Recommendation Report for Planning Permission

REF NO: EP/182/18/PL

LOCATION: 20 Lashmar Road
East Preston
BN16 1EY

PROPOSAL: 1 No. end of terrace house together with associated car parking, new vehicular access, garden shed & planting (resubmission following EP/148/17/PL).

SITE PLAN

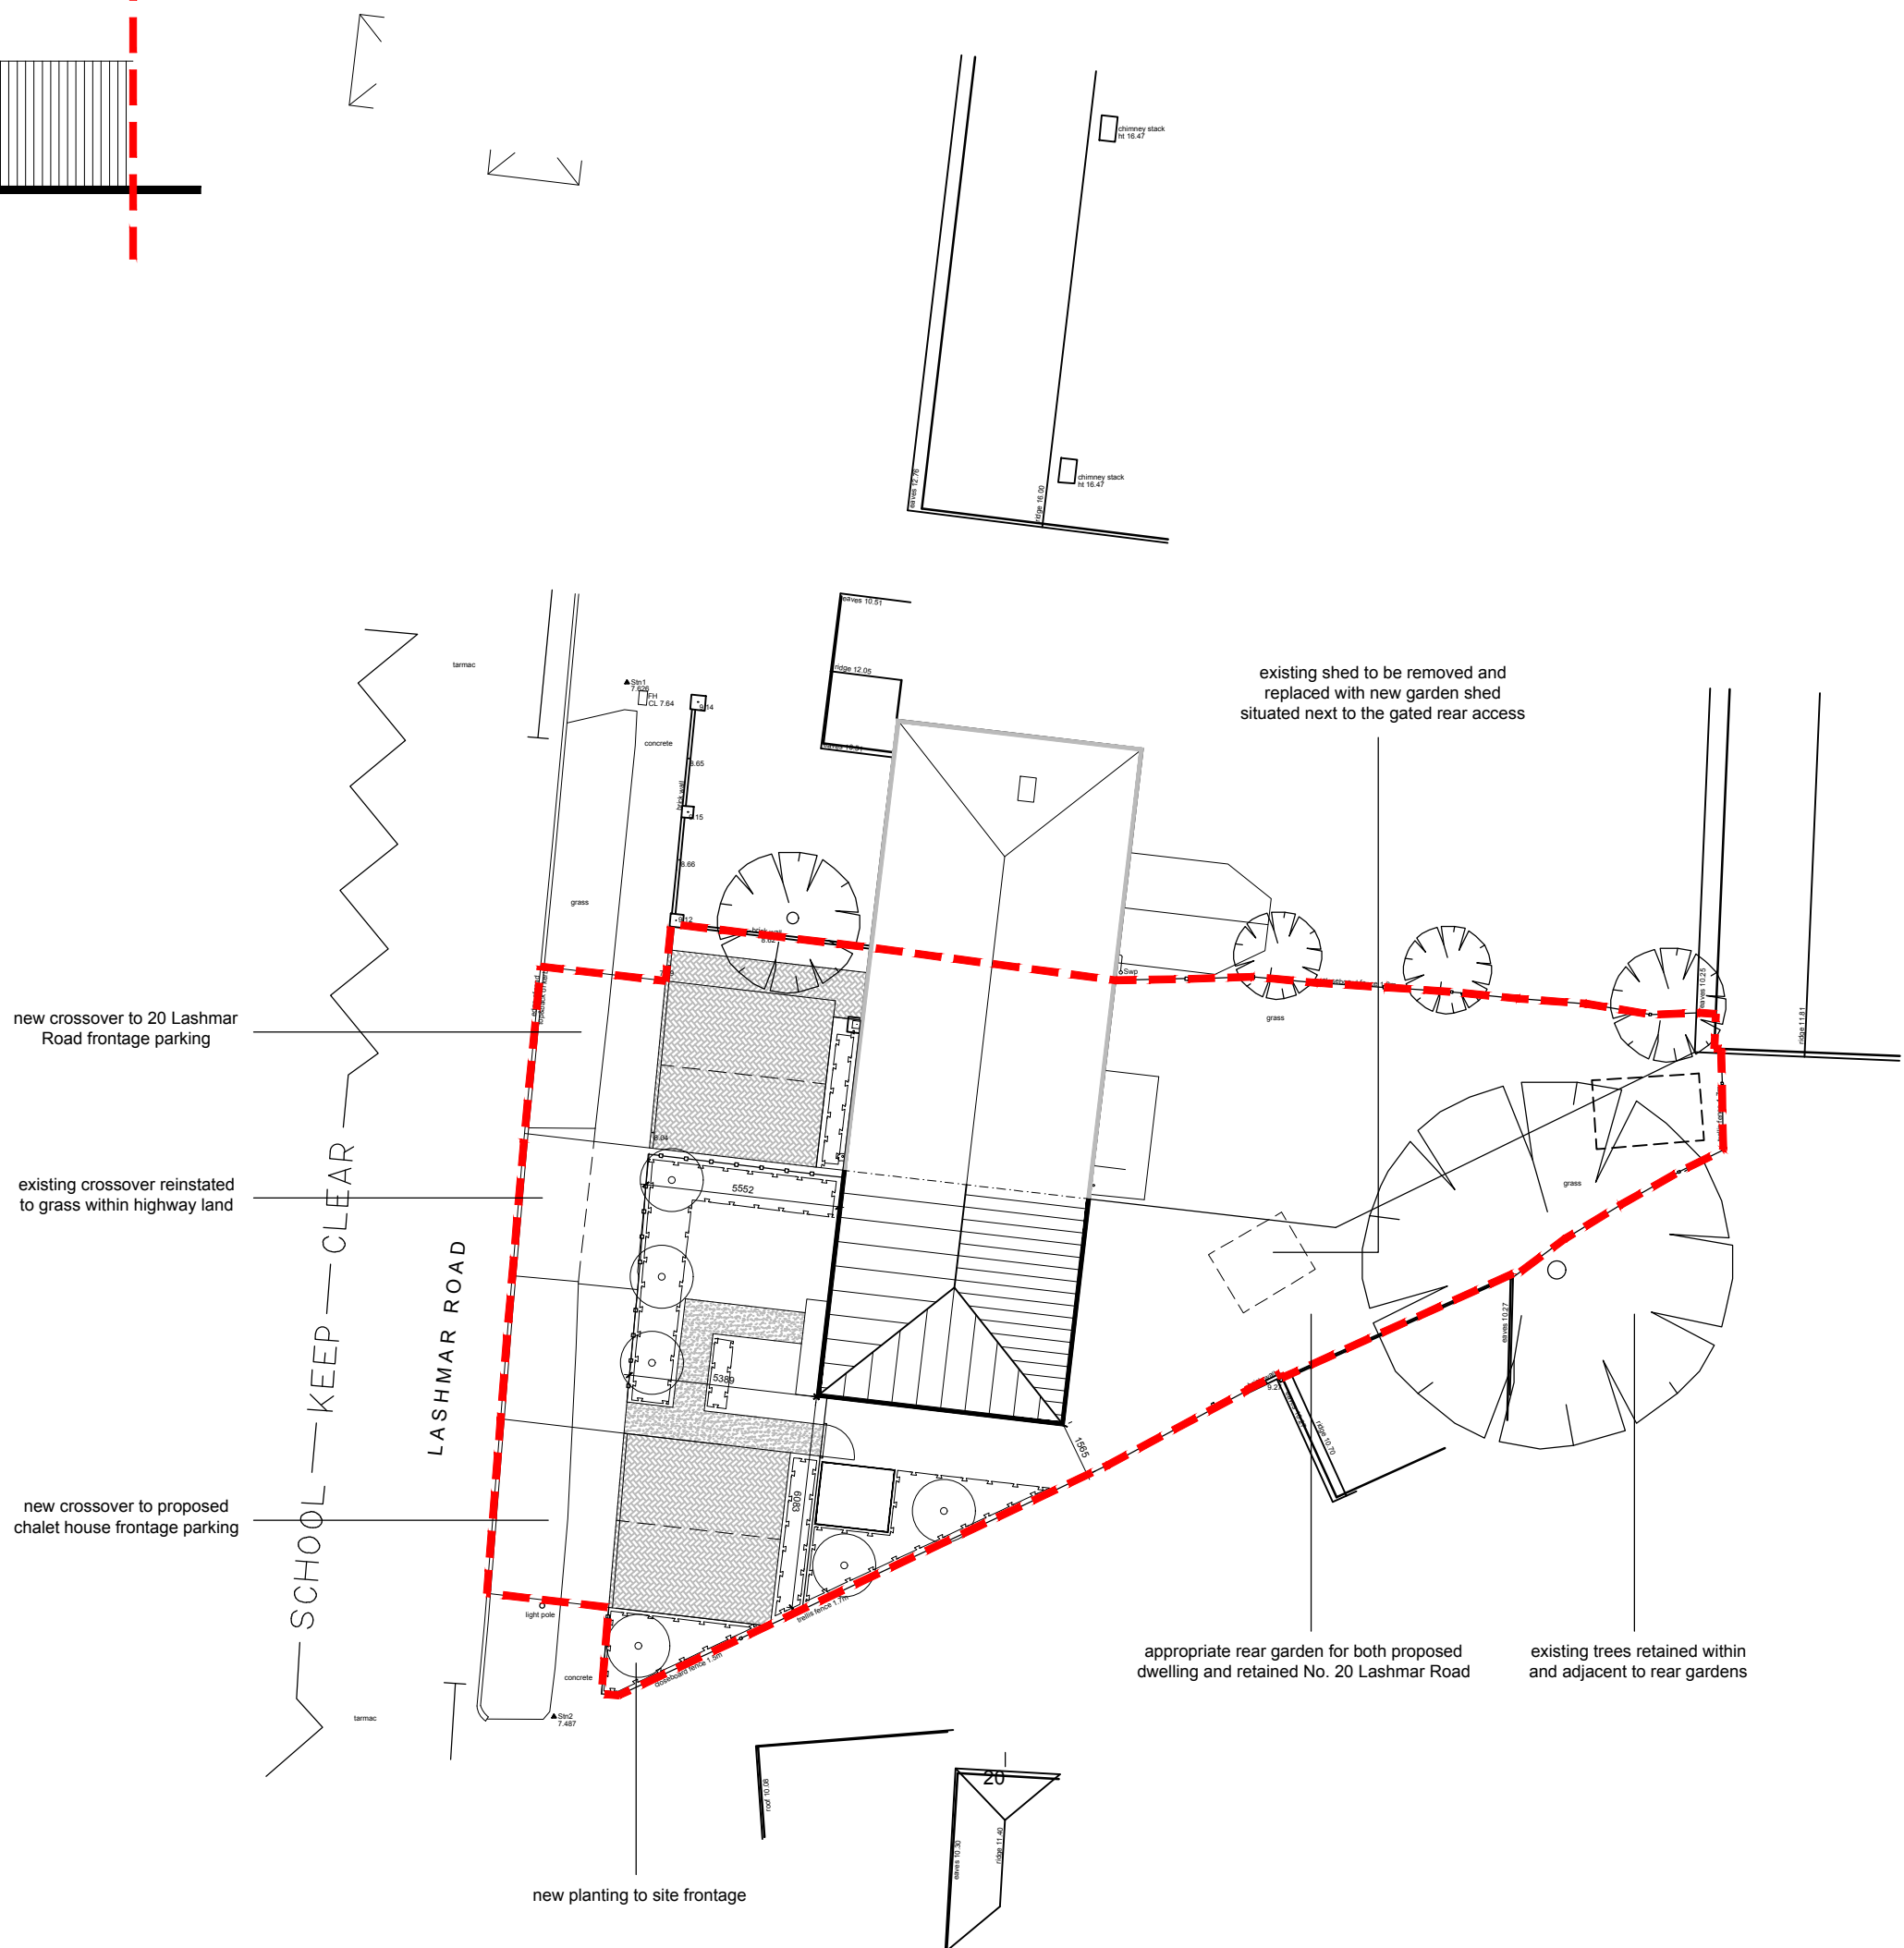
An inspection of the Design and Access Statement and site plan establishes that a new vehicle crossover (VCO) is proposed to provide access to the off-street parking spaces serving the new dwelling. A study of local mapping demonstrates that it is likely that the crossover works will require the relocation

of the street-lighting pole located on publicly maintained highway fronting the application site. These relocation works would need to be undertaken at the expense of the applicant. It is the responsibility of the applicant to liaise with the necessary parties to organise the moving of the street-lighting pole. The pole will need to be relocated at least 1.5m from the location of the top of the ramped kerb of the proposed crossover.

The Design and Access Statement confirms that the existing VCO serving no. 20 Lashmar Road is to be closed off and a new VCO created to serve the revised parking arrangements at this address. The two new proposed VCOs must be implemented under licence to a specification obtained from WSCC Highways.

A study of the online documents and plan establishes that 2 off-street parking spaces will be provided for the new dwelling. This is in accordance with the WSCC Parking Demand Calculator. The existing parking arrangements serving no. 20 will be re-configured to allow for 2 cars to park off-street on the property's frontage. The current access serving the existing driveway will be closed off.

A turn on-site would be preferred; clearly though there is insufficient space to achieve this. However, other properties have similar arrangements and balanced against this is the benefit of providing an opportunity to remove vehicles that would otherwise be parked on the highway in a location where the existing practice is on-street parking by residents which results in a noticeable narrowing of the existing available carriageway space.

With respect to external amenity space the proposed dwelling does have a small rear garden and does 'take' part of the remaining rectangular garden of the existing dwelling at 20 Lashmar Road. The new property would have an additional triangular garden to the side. The Council does not currently have external space standards and refers to advice within the National Planning Policy Framework para 127

which requires that new development provide ' a high standard of amenity for existing and future users'. The rear garden space would be approx. 80 sq.m. of garden space for the property proposed and the existing semi detached property would be left with a rear garden of approximately 73 sq,m, both of which would have a length in excess of 10 metres. The proposed development is considered acceptable with respect to external amenity space.
